CHENNAI METROPOLITAN DEVELOPMENT AUTHORITY
Thalamuthu Natarajan Building, No.1, Gandhi Irwin Road, Egmore,
Chennai - 600 008
Phone : 28414855 Fax: 91-044-28548416
E-mail: mcmda@tn.gov.in
Web site: www.cmdachennai.gov.in

Letter No. C3(N)/19019/2016, dated .04.2017

Sub: CMDA – APU – MSB (North) Division – Planning Permission Application for the proposed construction of Multi-storied Group Development building consisting of 2 Blocks commercial cum residential use, at Block No. 1 - G.Floor + 1st Floor + 2nd Floor (Commercial use) + Service Floor and 3rd Floor to 12th Floor (Residential use with 60 dwelling units) and Block (Amenity Block) No. 2 - Stilt Floor + 4Floors (Stilt + 1st & 2nd Floor for Puzzle Parking up to 8.40 m height accommodating 17 Nos of car parking and Gym & Multipurpose Hall at 3rd & 4th Floor) at rear side. In survey No. 219/ 2A, 2B1B & 24 of Kattupakkam Village, Poonamallee High road, Chennai, within the limits of Poonamallee Panchayat union - Applied by **M/S. Pooja Foundation Pvt Ltd (Rep. by its Director B. Budhmal Bohra) & Others, (GPA Holder)** - Proposal placed before the MSB Panel - Recommended and forwarded to Government for Approval –Reg.

DRAWING TITLE:
 BLOCK - 1 :
 11TH FLOOR PLAN & 12TH FLOOR PLAN

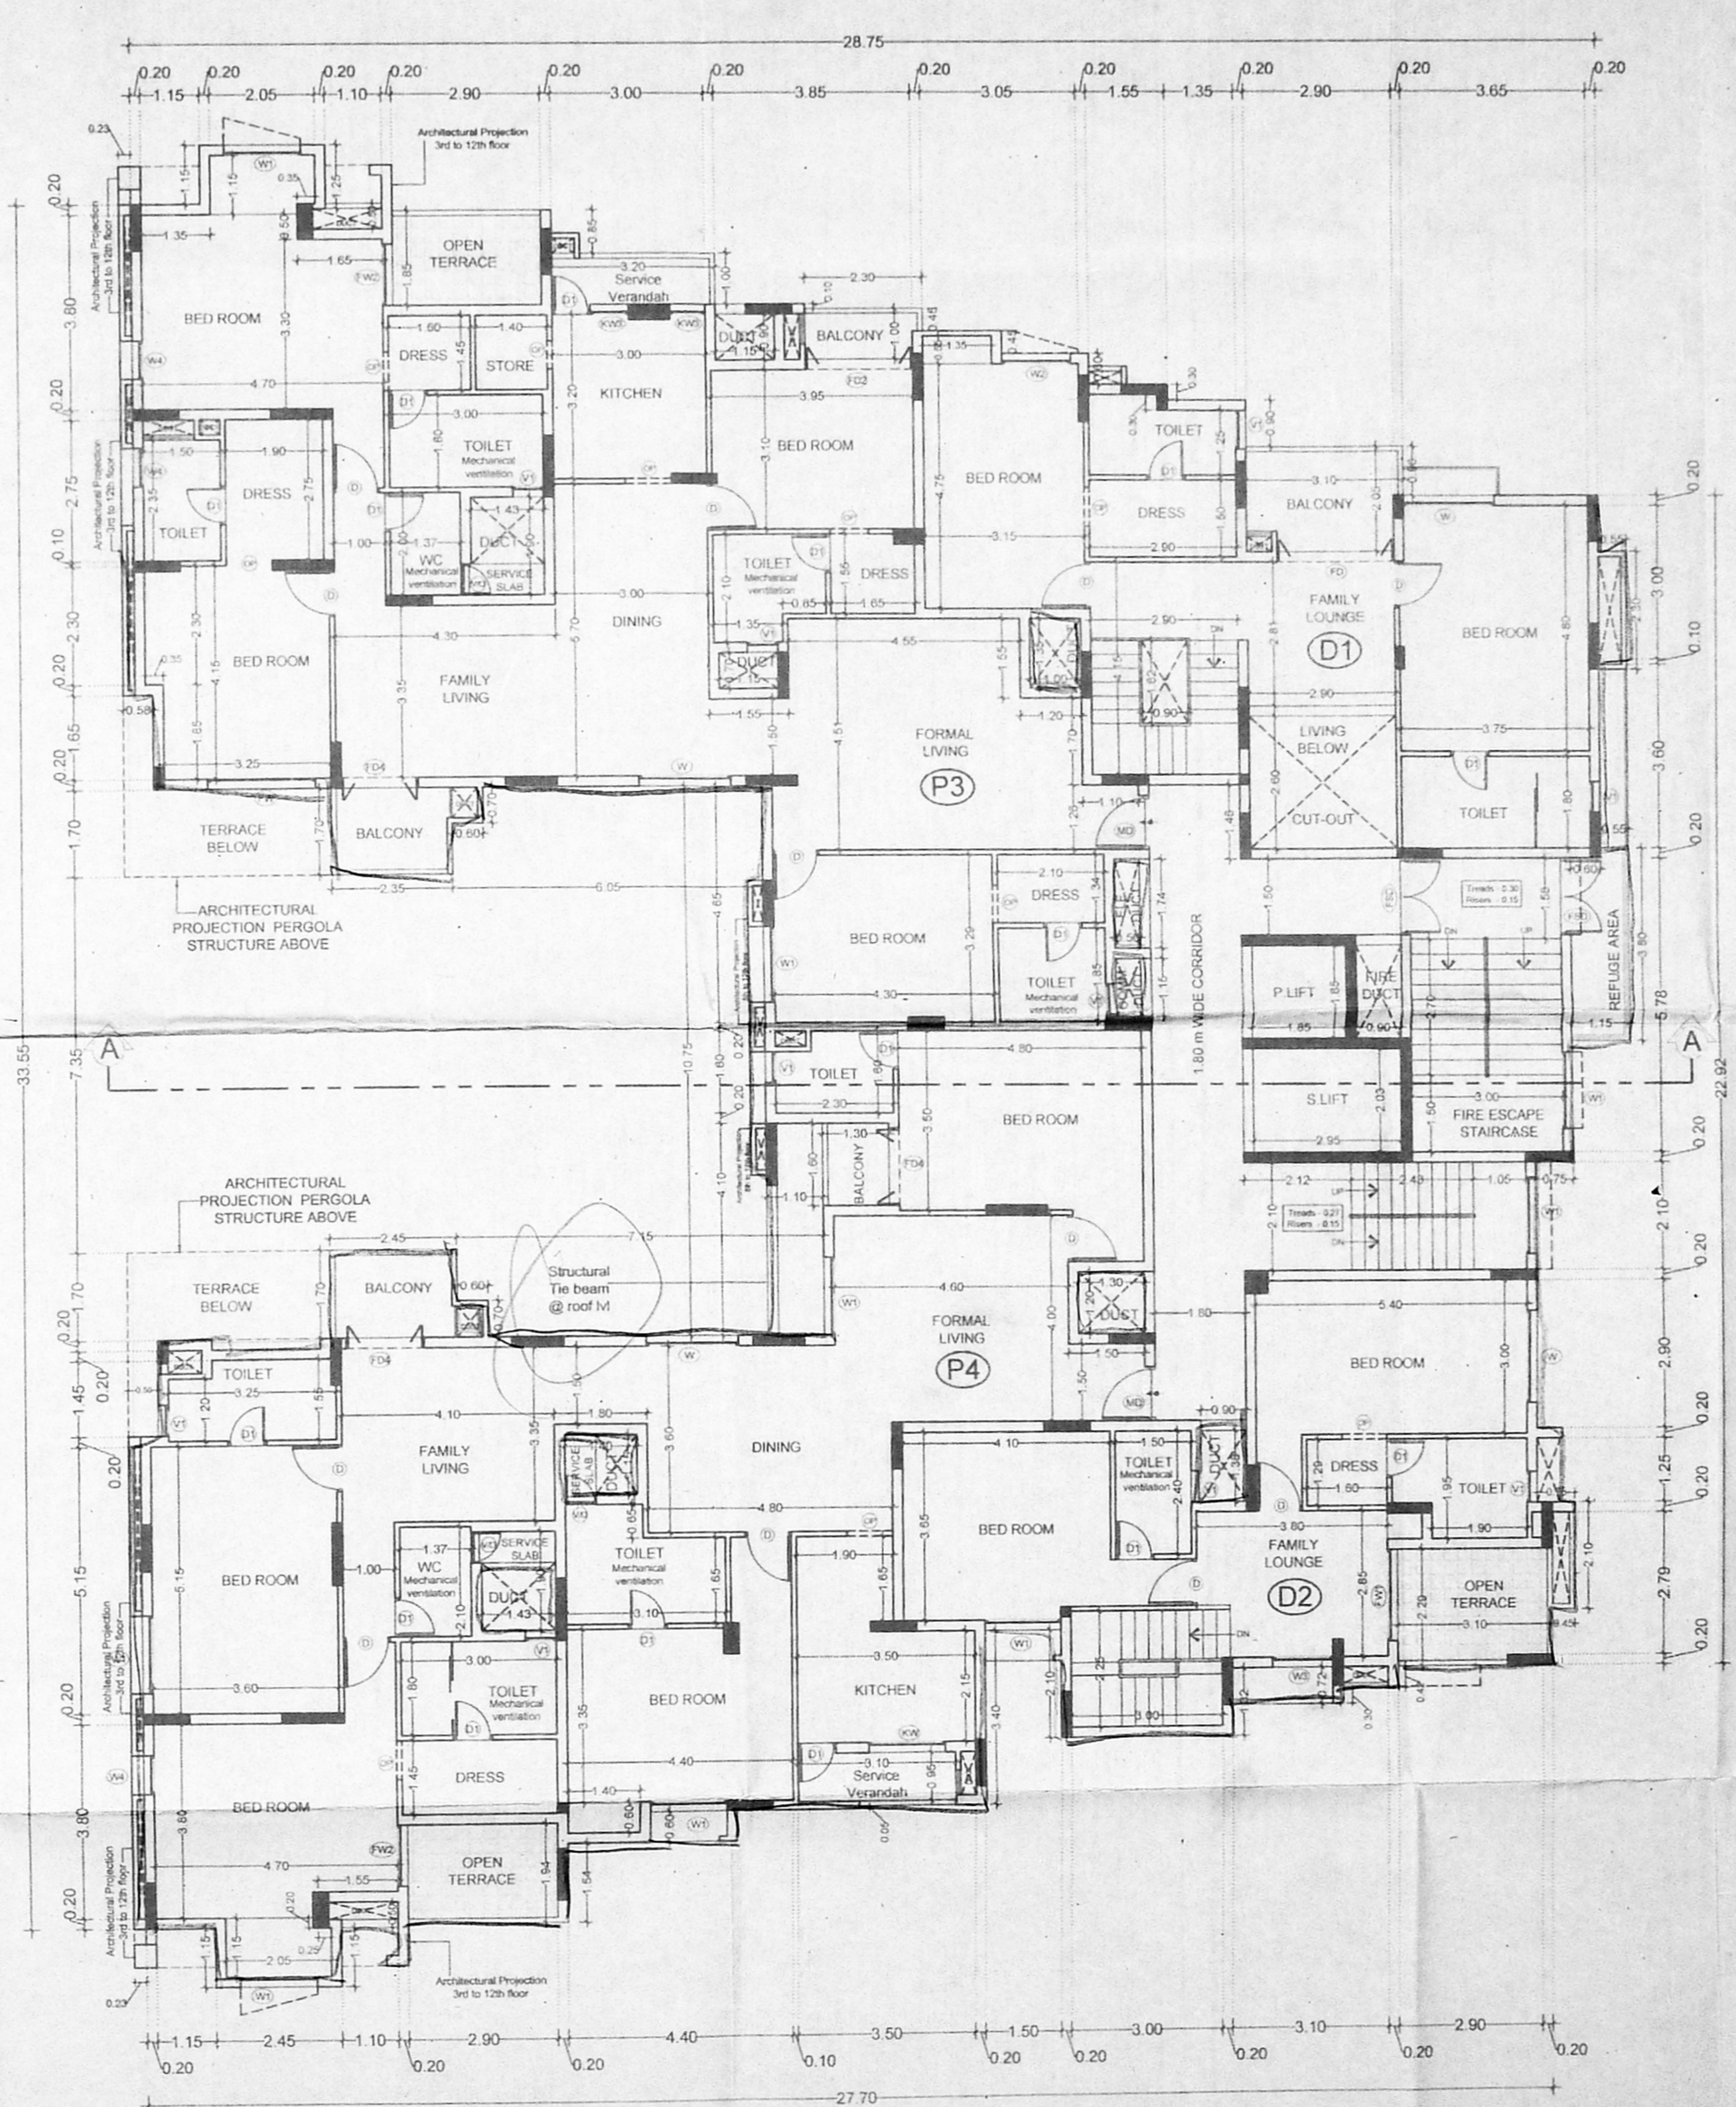
18. Low terrace area at 5th floor & in typical floor are to be shown properly.
19. Cut out to be revised as open terrace area at 5th floor.
20. Door entry proposed to open terrace area at 11th & 12th floor are to be closed.

DRAWING TITLE
 BLOCK - 1 : ELEVATION & SECTION

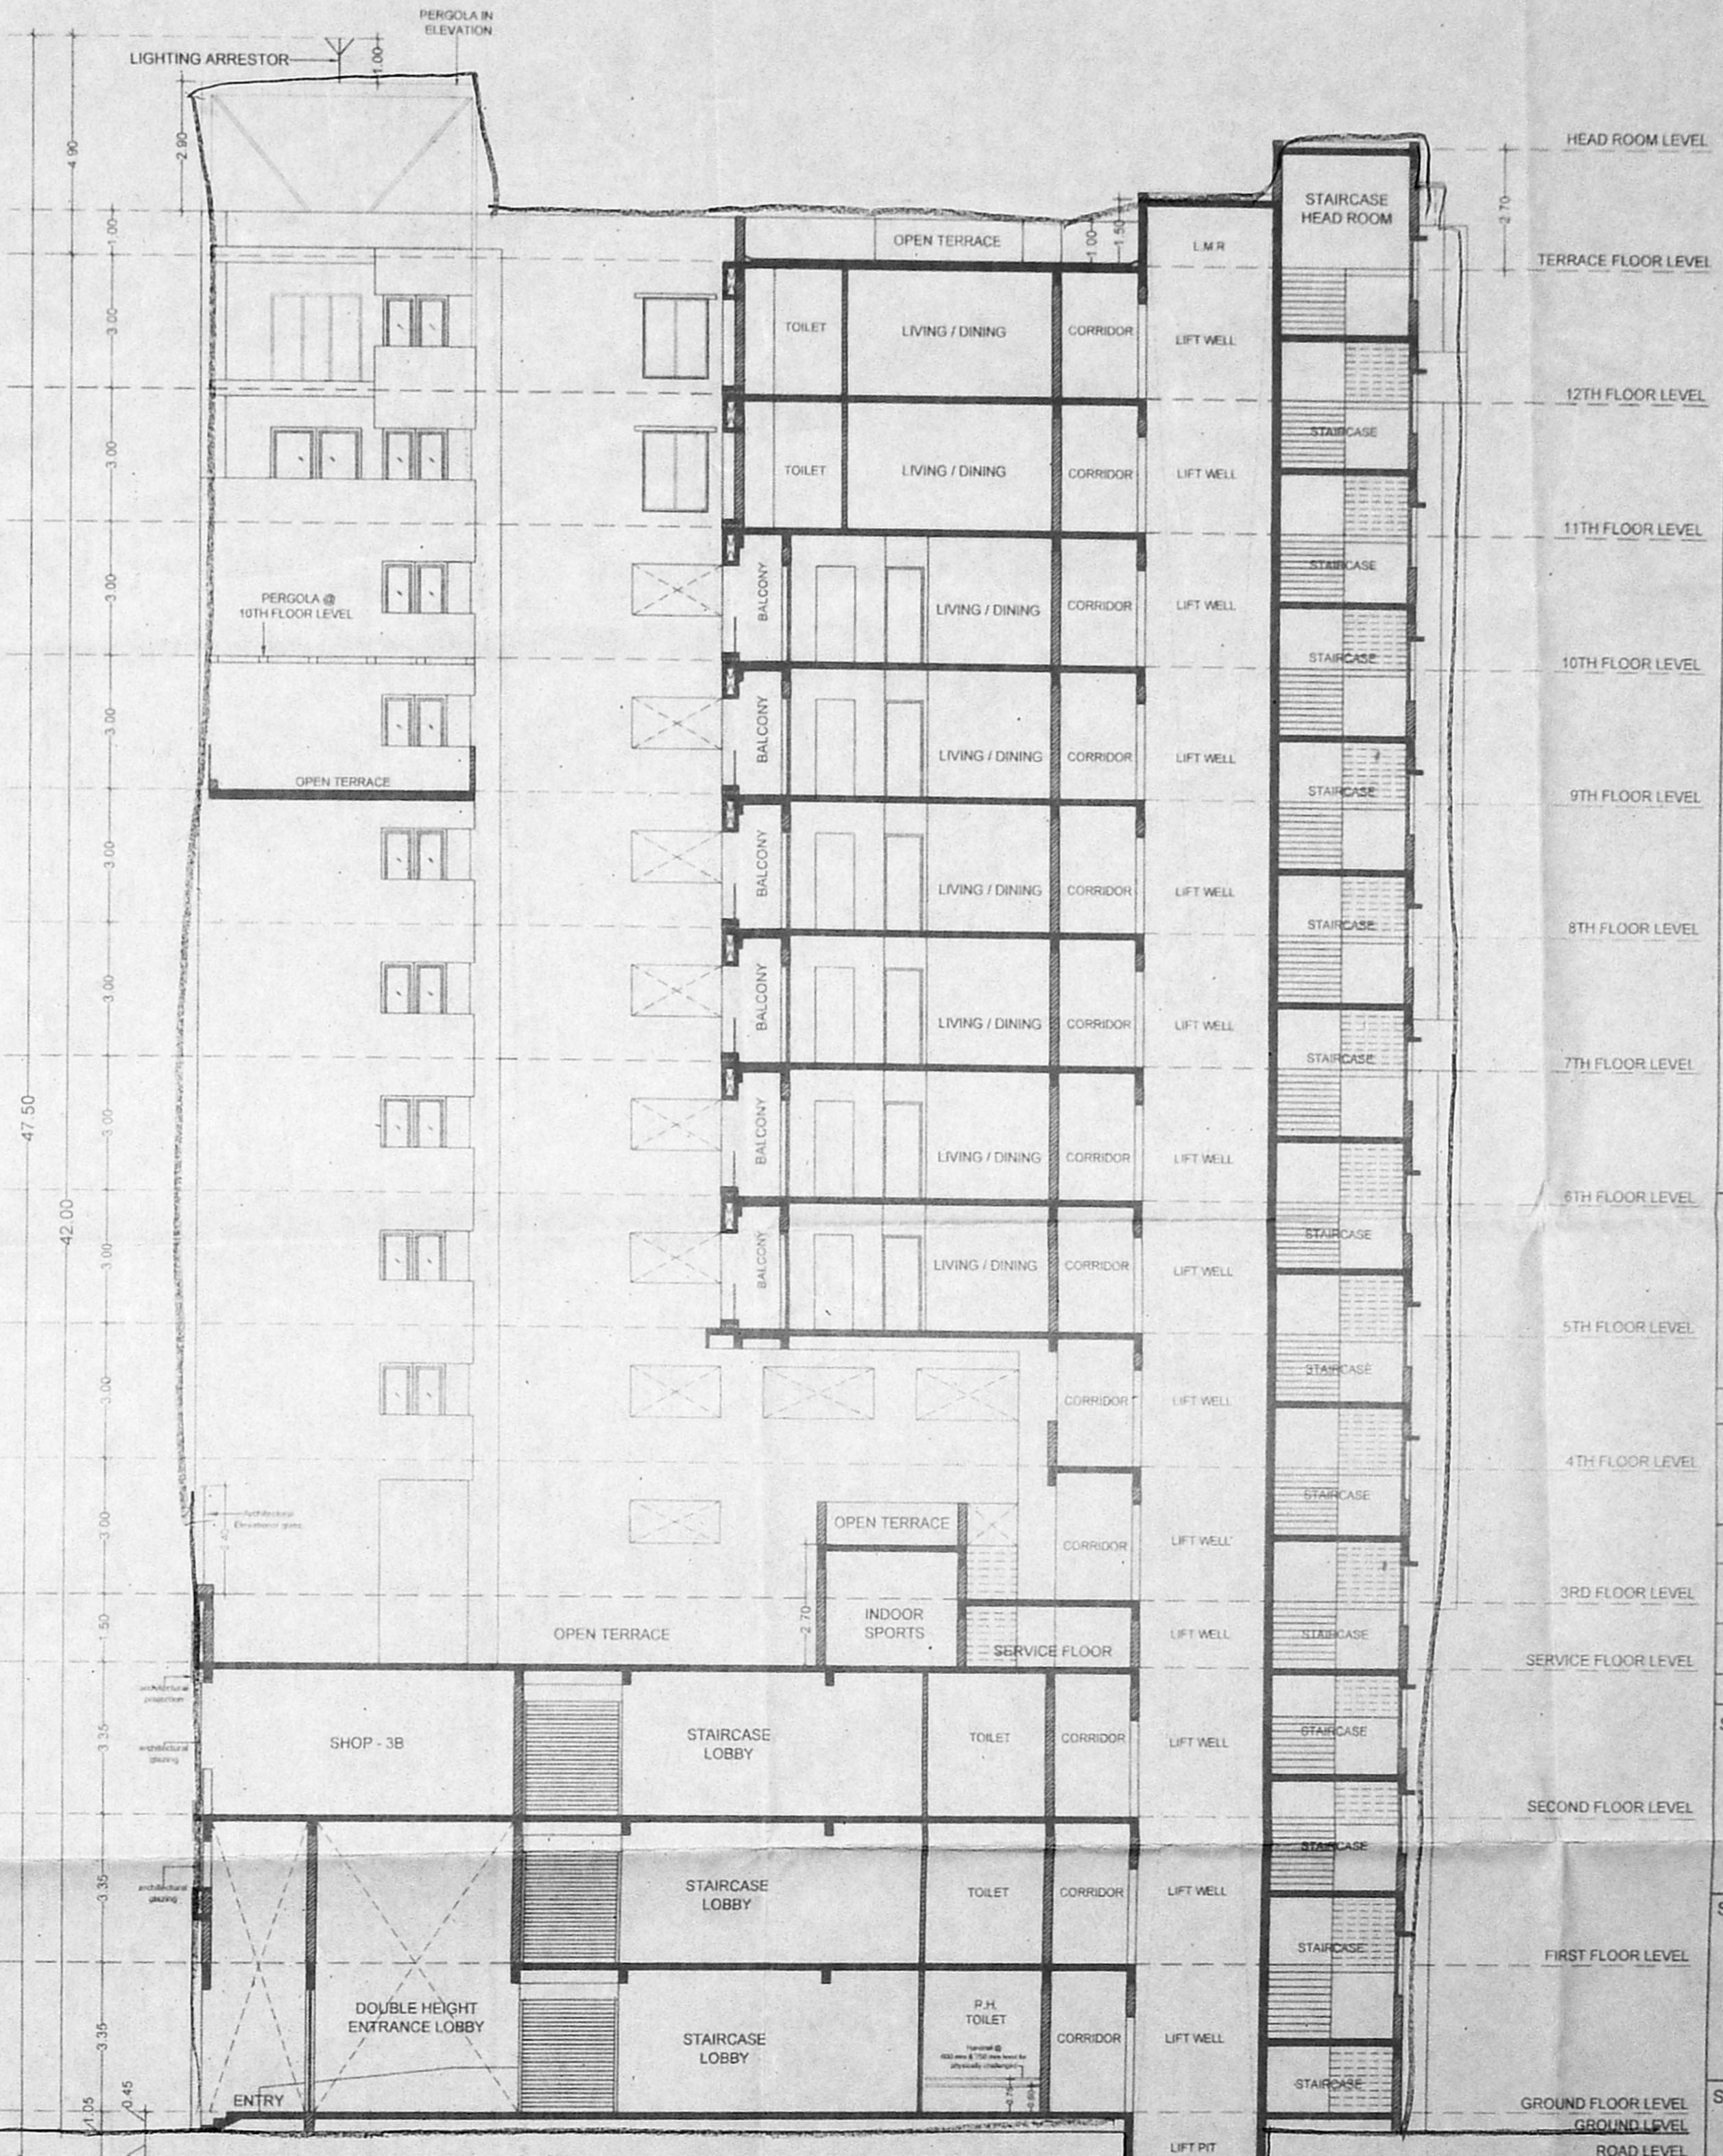
22. OTS/DUCT is to be specified properly and cross section along the ramp to be furnished.
23. Sub title to be corrected as Elevation on which side.
24. Fire escape ramp to be specified in all floor plans.
